PORTISHEAD BRANCH LINE (METROWEST PHASE 1) DEVELOPMENT CONSENT ORDER

DRAFTING NOTE ON THE SECRETARY OF STATE'S "MINDED TO" DRAFT DCO

2.29 – Compound, Haul Road and Access to Works Plan

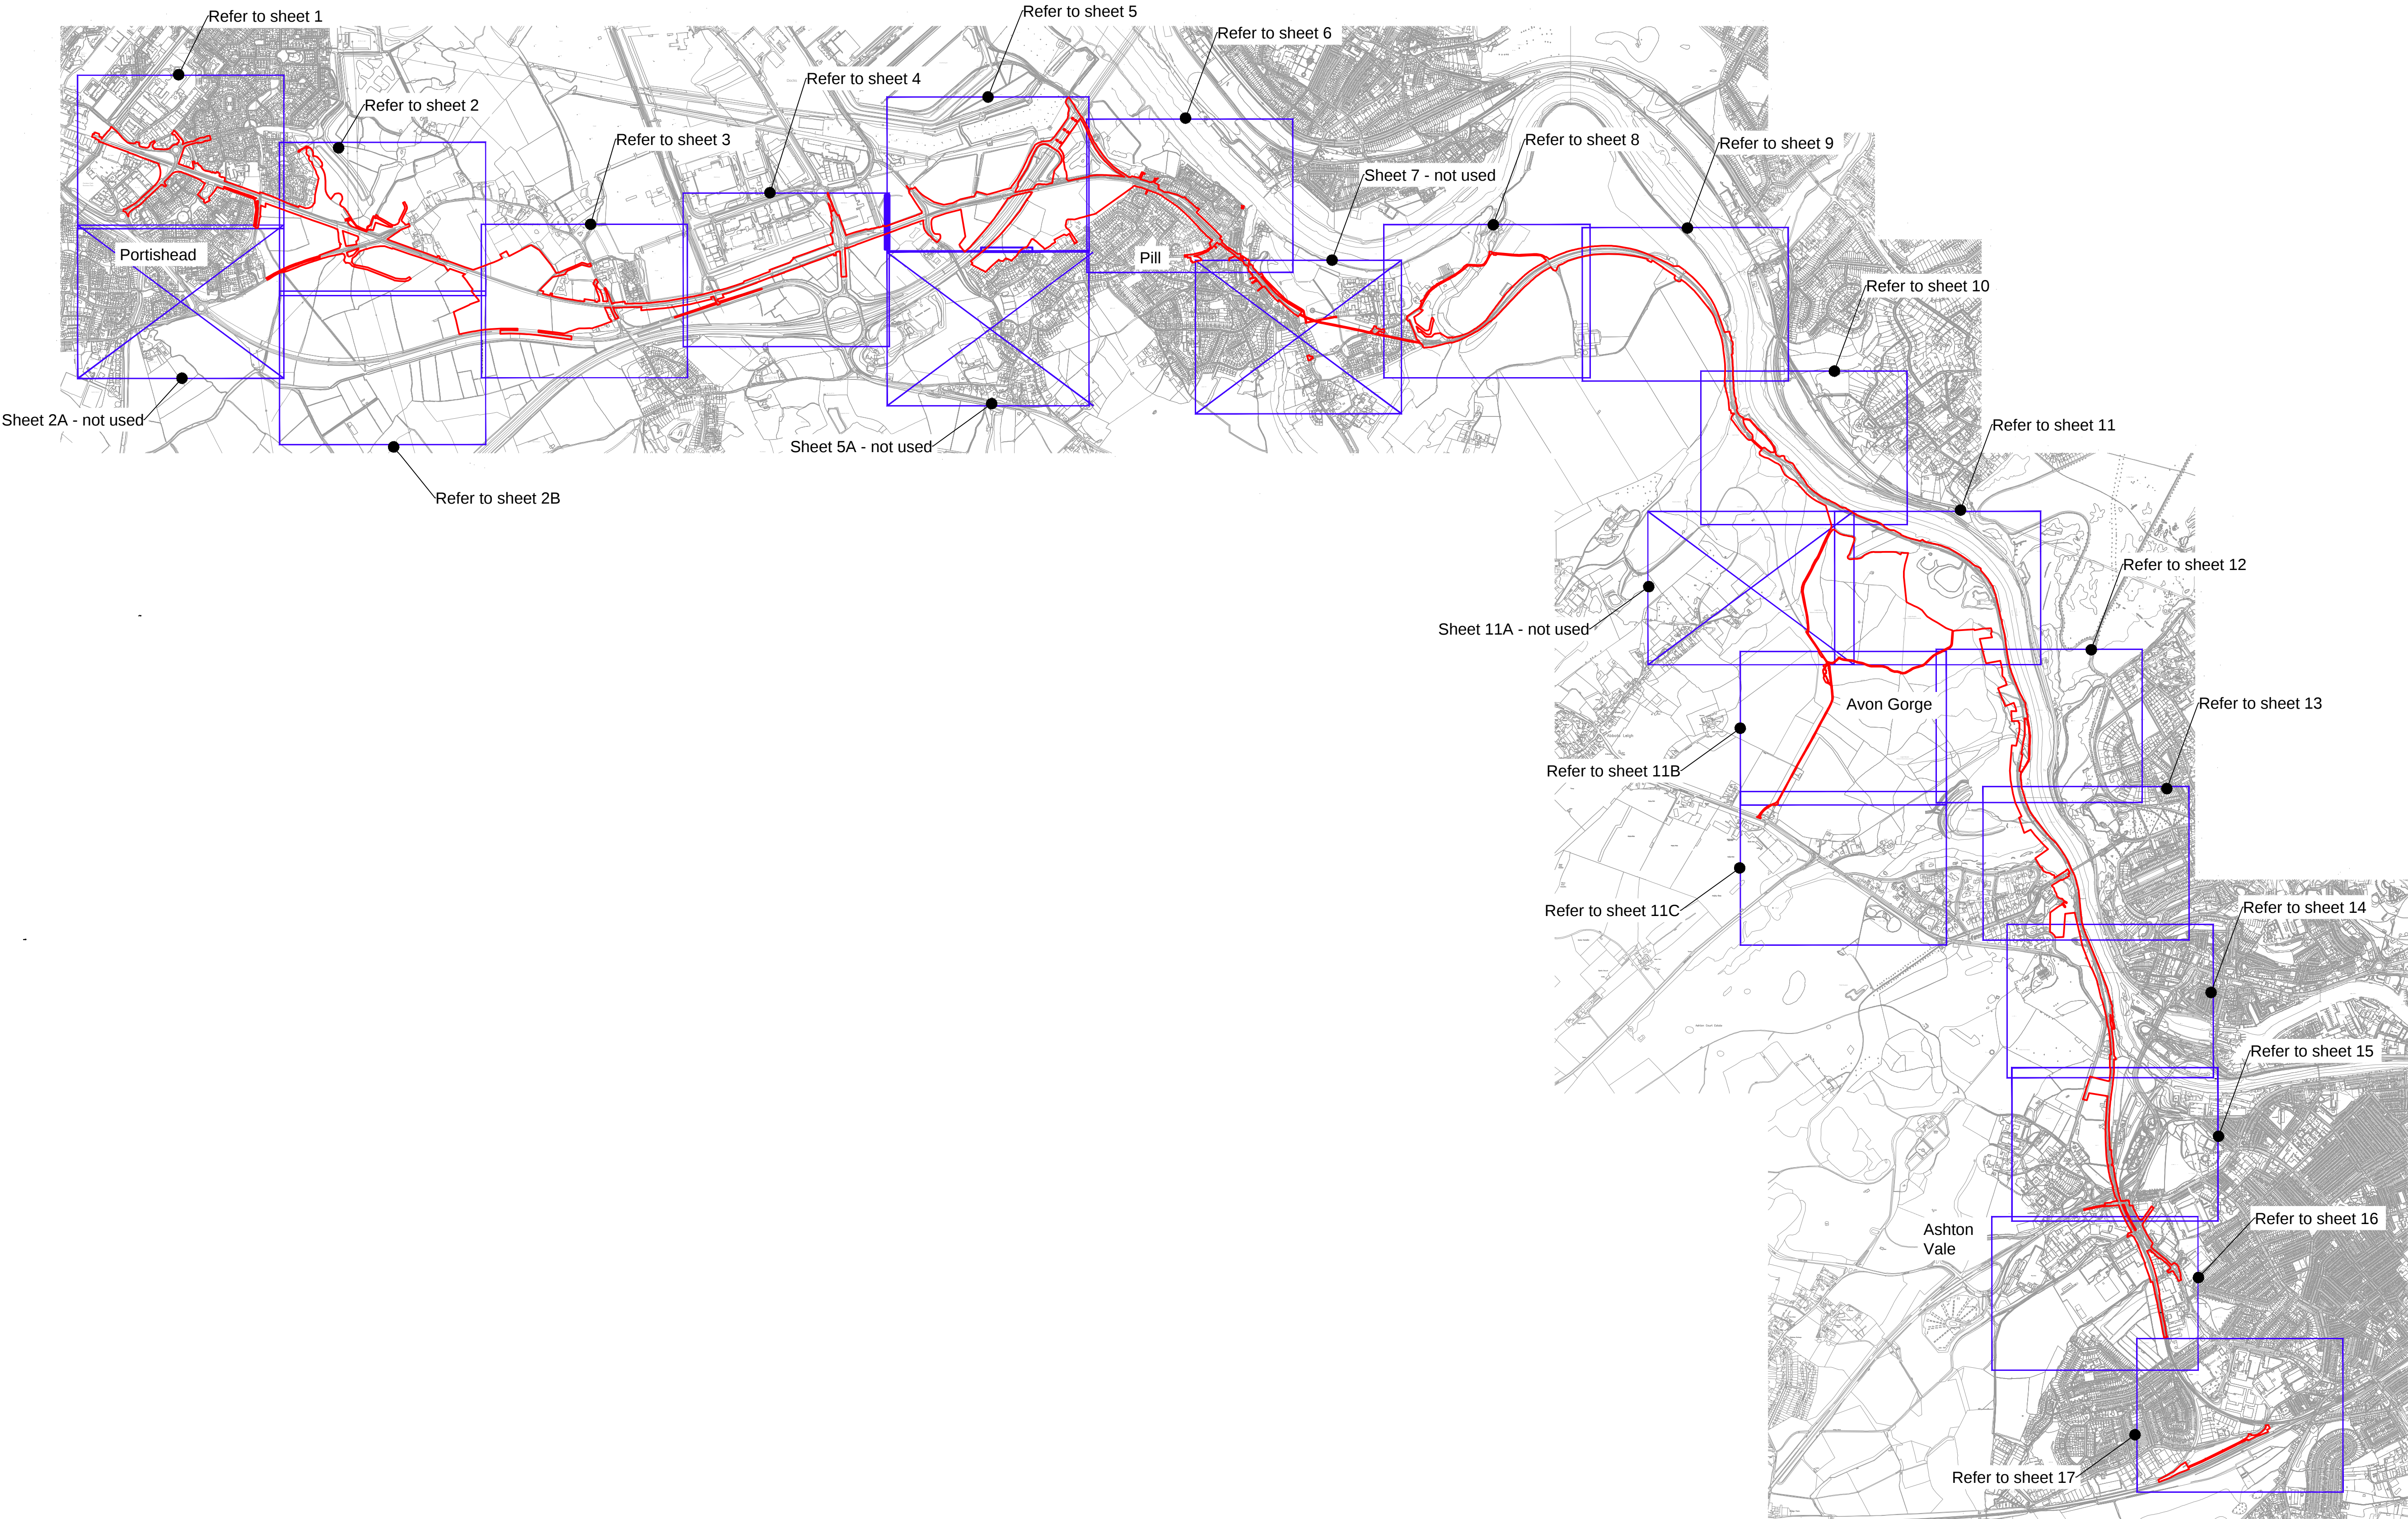
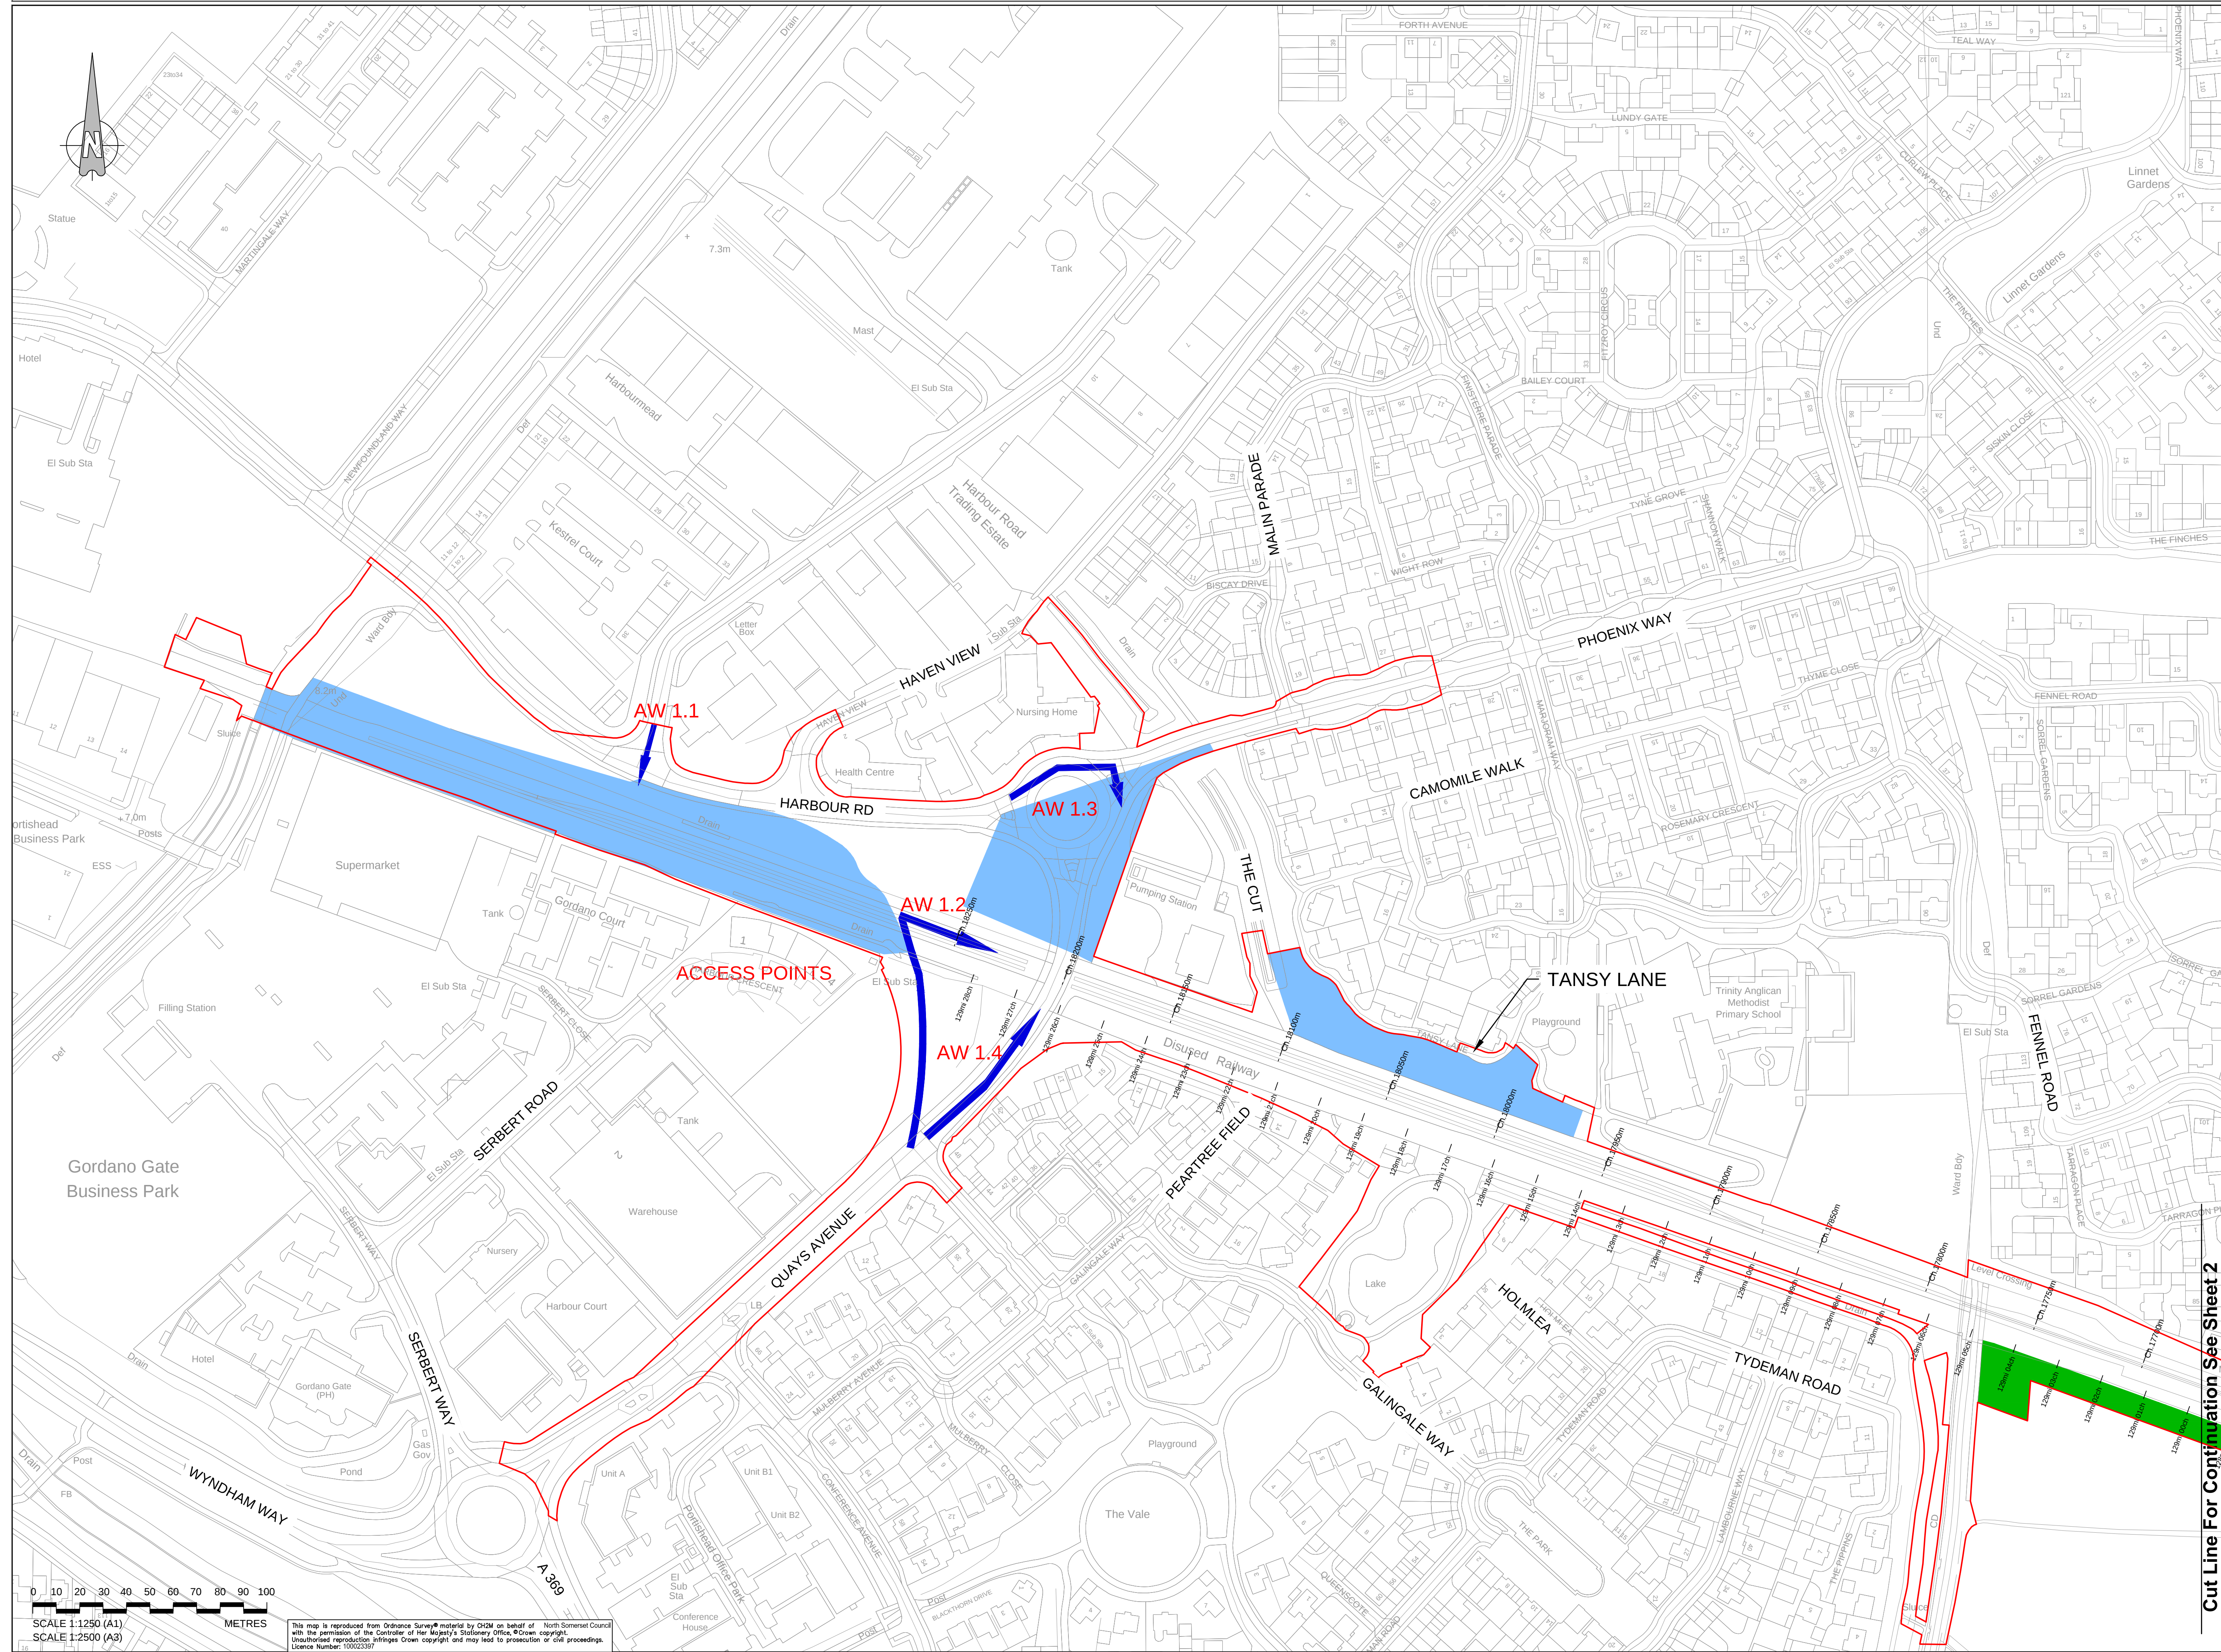
2.9 The changes made to DCO Requirement 30, in particular that “.....[to show the proposed levels for the flood compensation mitigation area to be 7.3m AOD.....](#)”, are a major concern as a level of 7.3m AOD may not be achievable.

2.10 The current ground level is 7.5m AOD and the Applicant proposed to lower the level to 7.4m AOD. Lowering the level by a further 10cm to 7.3m AOD presents a number of challenges:

(a) There are a number of utilities located within this site including; a culverted watercourse, surface water drain/sewer and a foul sewer. These all need to have sufficient depth below ground according to the relevant technical requirements of the utility company owners. The

utilities will require protection measures over the top of apparatus and the need to maintain a minimum depth below ground level for the buried apparatus. This is particularly the case in the context of the Applicant's proposed use to operate HGV low loaders within the compound.

- (b) Lowering the land by a further 10cm will affect the Applicant's proposed ramp design, given the change from the ground level to the track level. Lowering the land by a further 10cm will result in either the length of the ramp being increased or the gradient of the ramp being increased. Lengthening the ramp is problematic because there may not be sufficient space while retaining the ability to operate a HGV low loader, given the constrained site size. Increasing the gradient of the ramp is problematic as that may not accord with engineering and safety design standards.

- (c) Lowering the land by a further 10cm could cause the compound to be water logged for periods of time which could have a detrimental impact on the usability of the compound for Network Rail. This could be problematic as Network Rail need to have the ability to use this compound/ access point at all times for the safe operation of the railway, to respond to any incidents arising on the railway.

- 2.11 The modified Requirement 30 text proposed by the ExA and Secretary of State could present major deliverability challenges for the Applicant.
- 2.12 We believe there may be other design solutions available, that would not necessarily involve lowering the ground to 7.3m AOD, but still achieve the required flood storage capacity.

- 2.13 These alternative solutions can be explored during the detailed design stage which is scheduled to commence in the coming months, in consultation with the relevant planning authority and the Environment Agency. Requirement 30(3) has been amended to provide for alternative design solutions in a mark up of the Order accompanying this note.
